RE: Lovelace Heights Addition – 2121 Yale Blvd SE
Erosion and Sediment Control Plan
Engineer's Stamp Date (missing) (M15E021)

Please find below our comment responses addressing the ESC Plan first review. This letter is to address comments we received from you on May 24, 2022. To facilitate your review, we have included the original conditions in *italicized* font and have provided our responses in **bold blue**.

SF-1. SILT FENCE

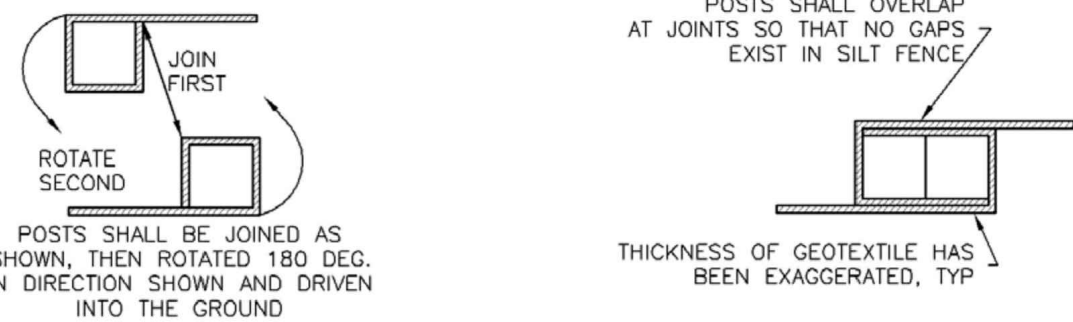
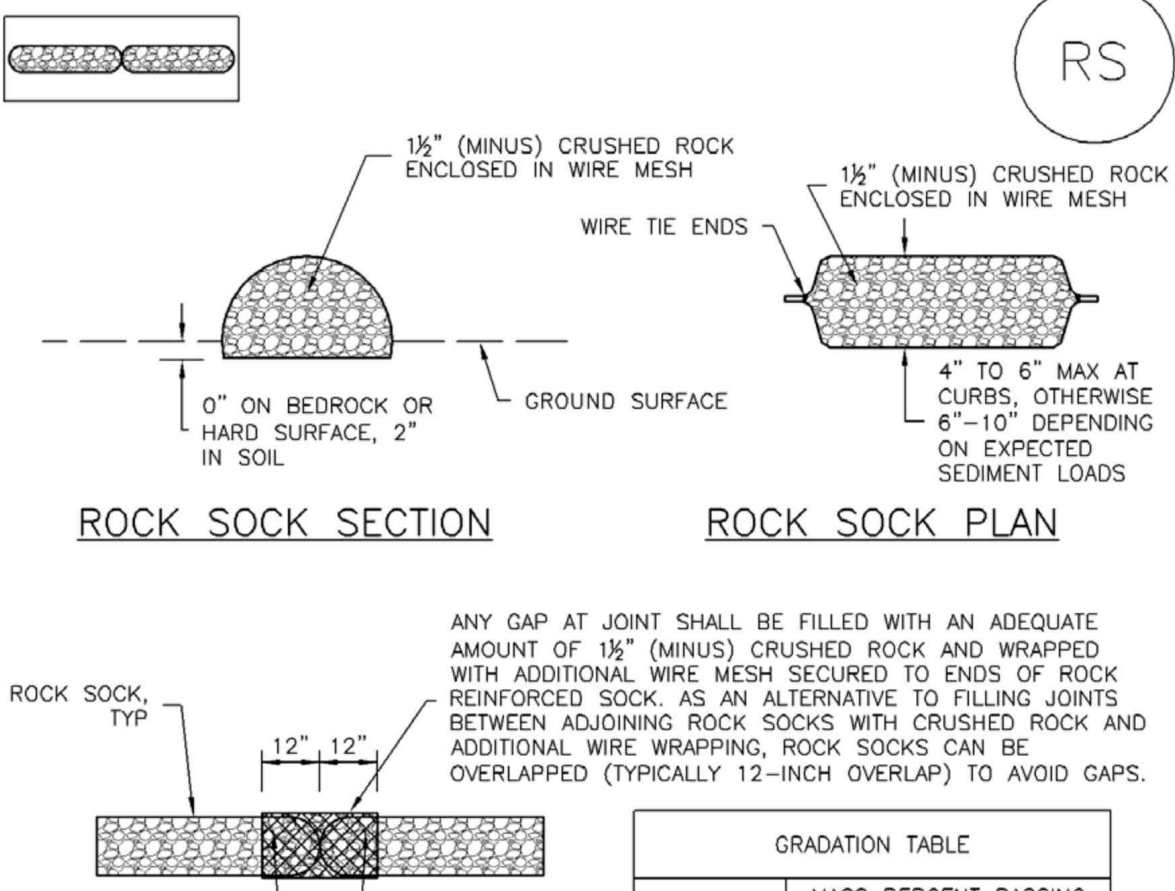
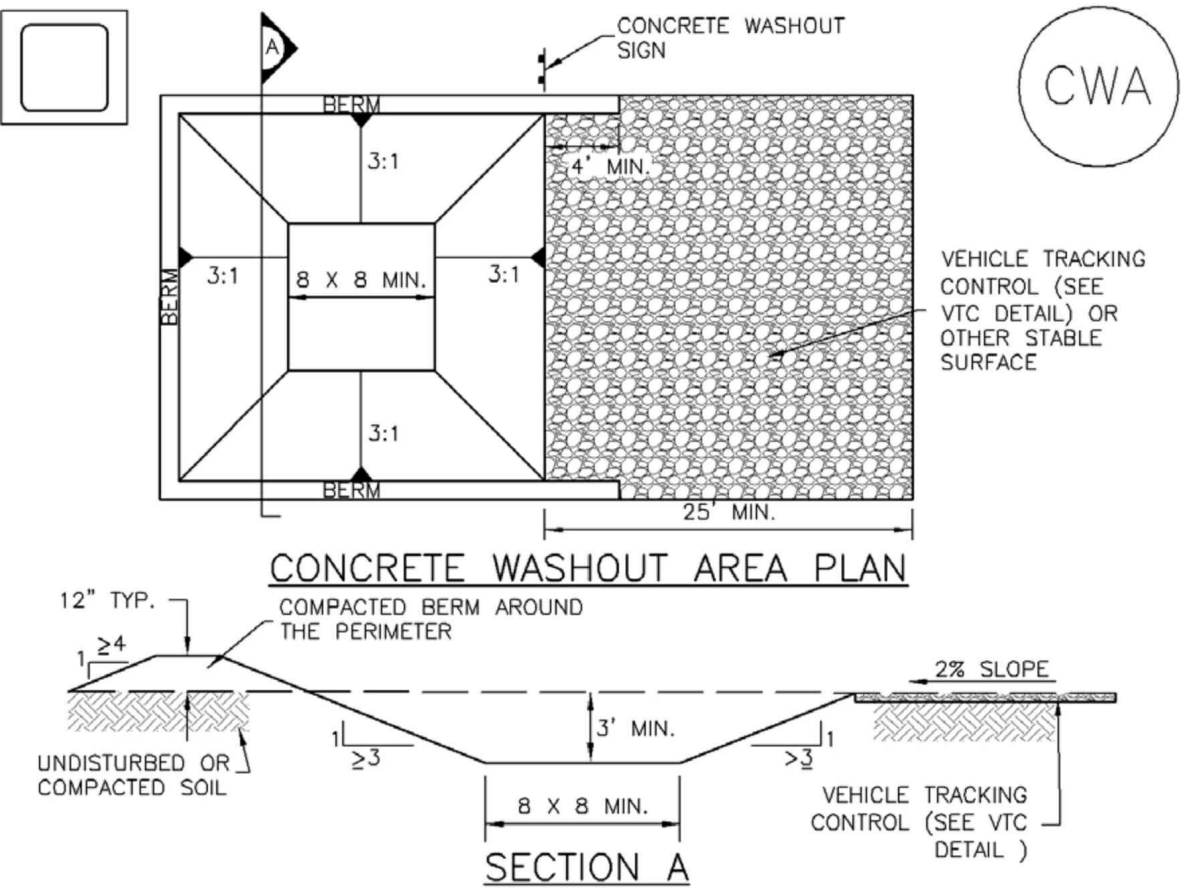
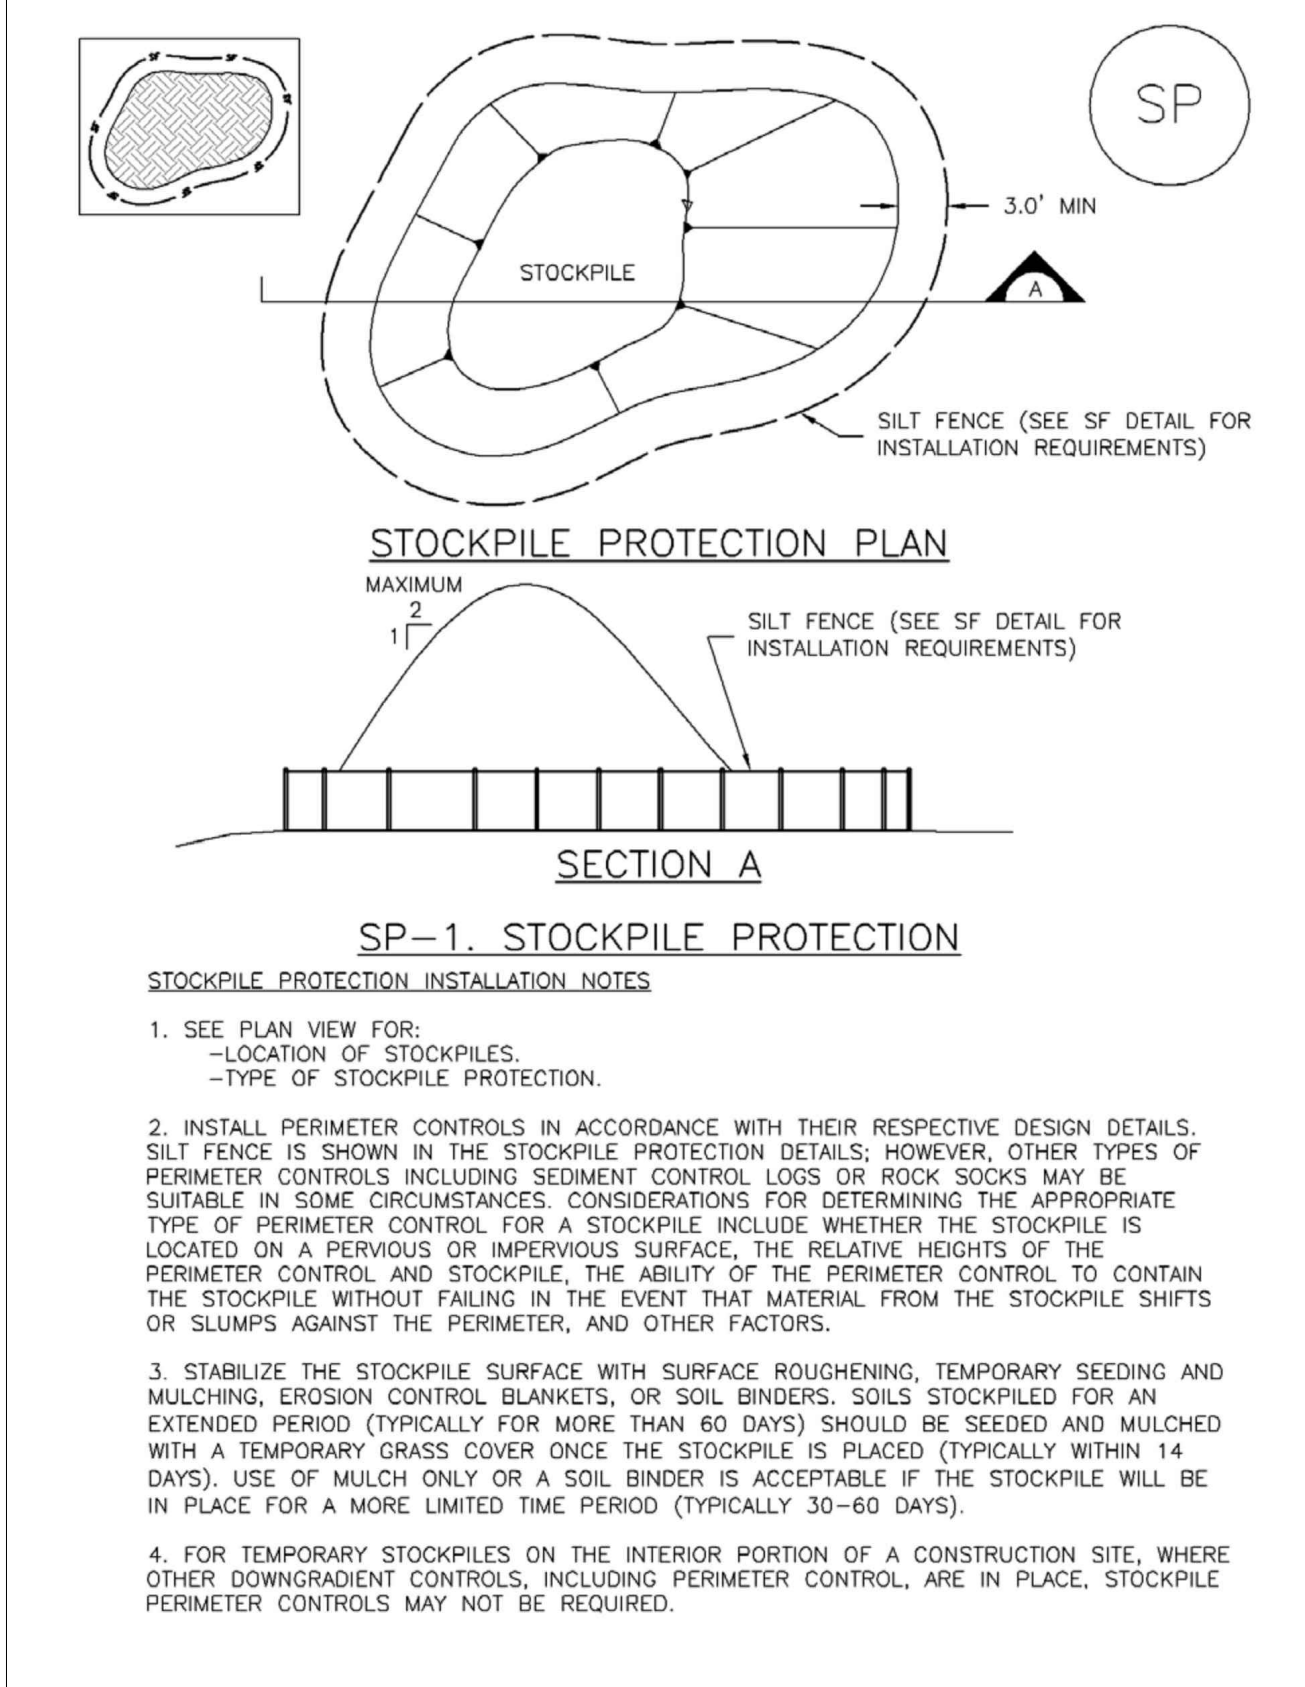
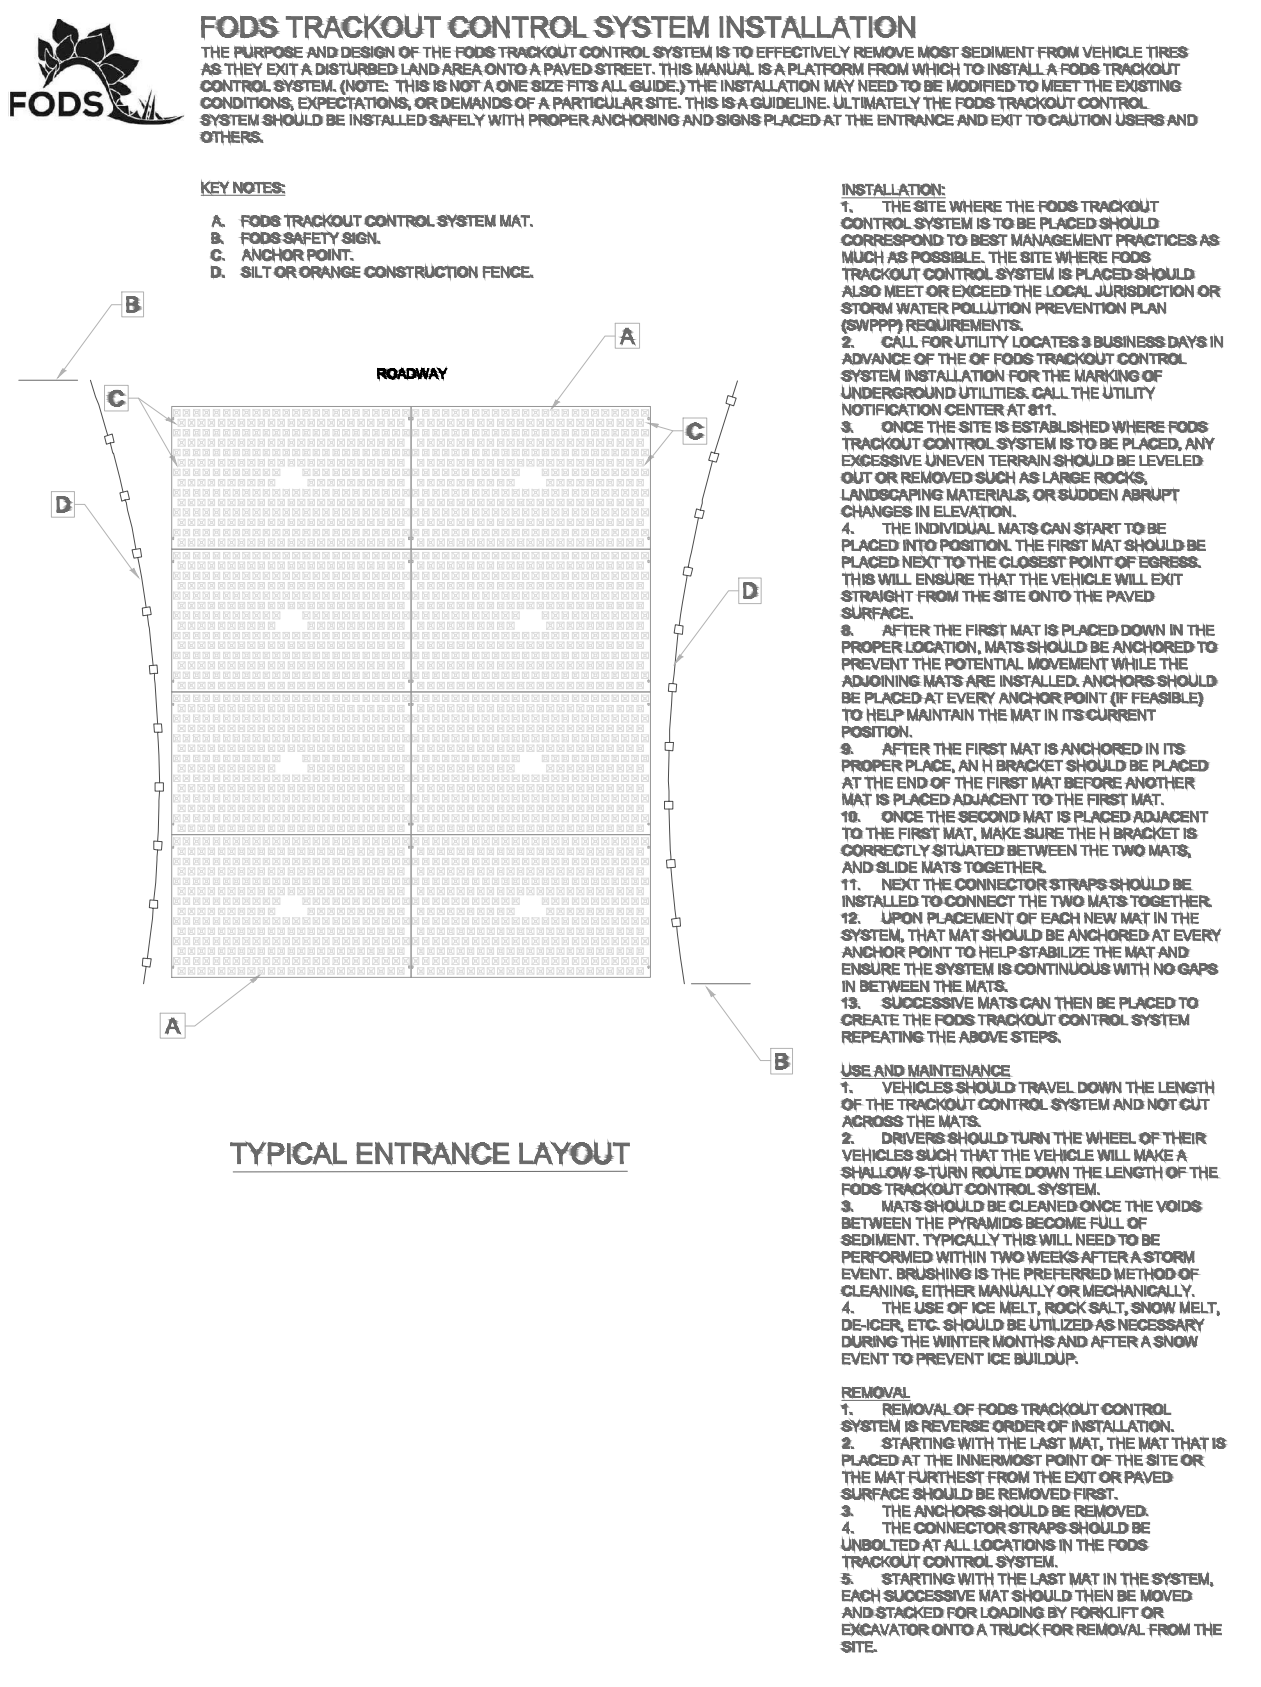
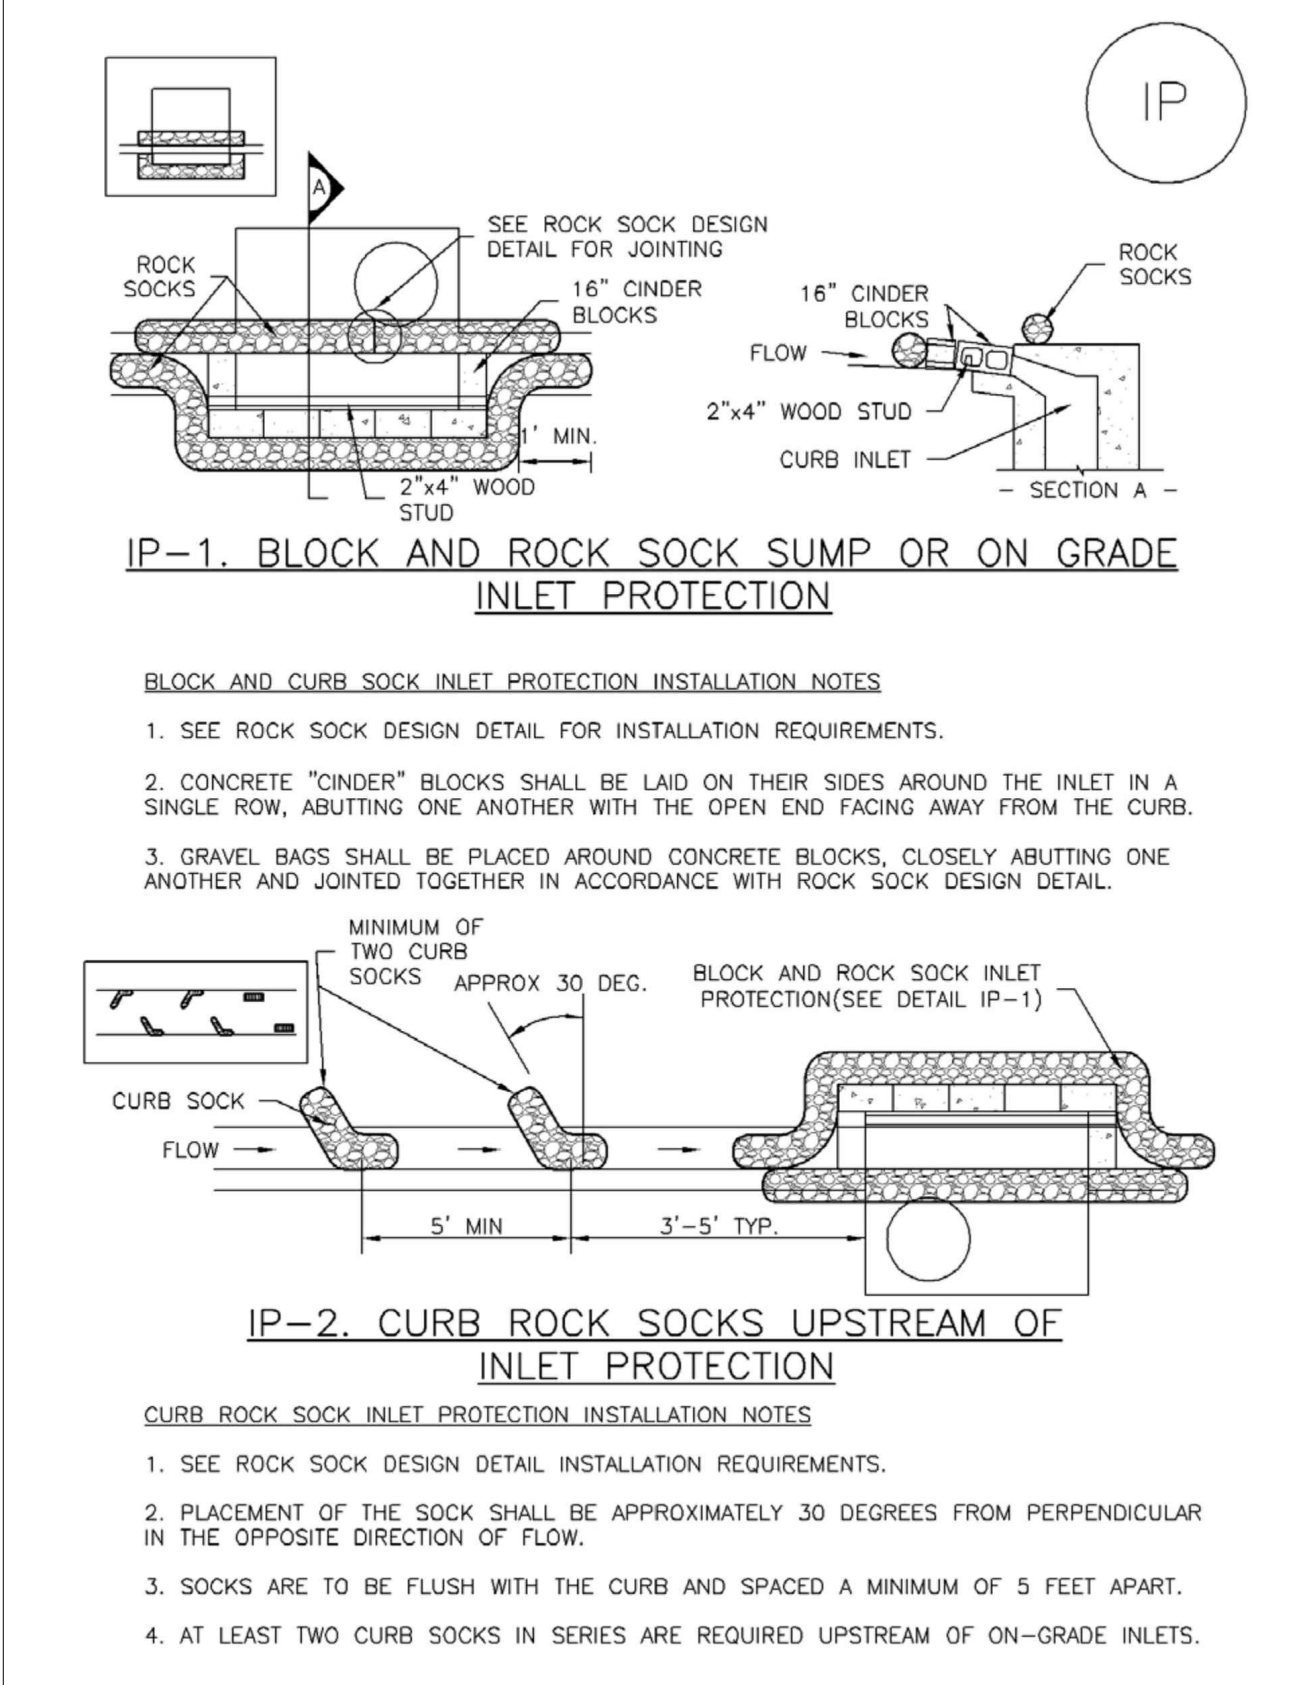
9. The notes on the construction details on sheets 6.7 and 6.8 are blurred, are not legible, and must be replaced.

Response: Revised as requested.
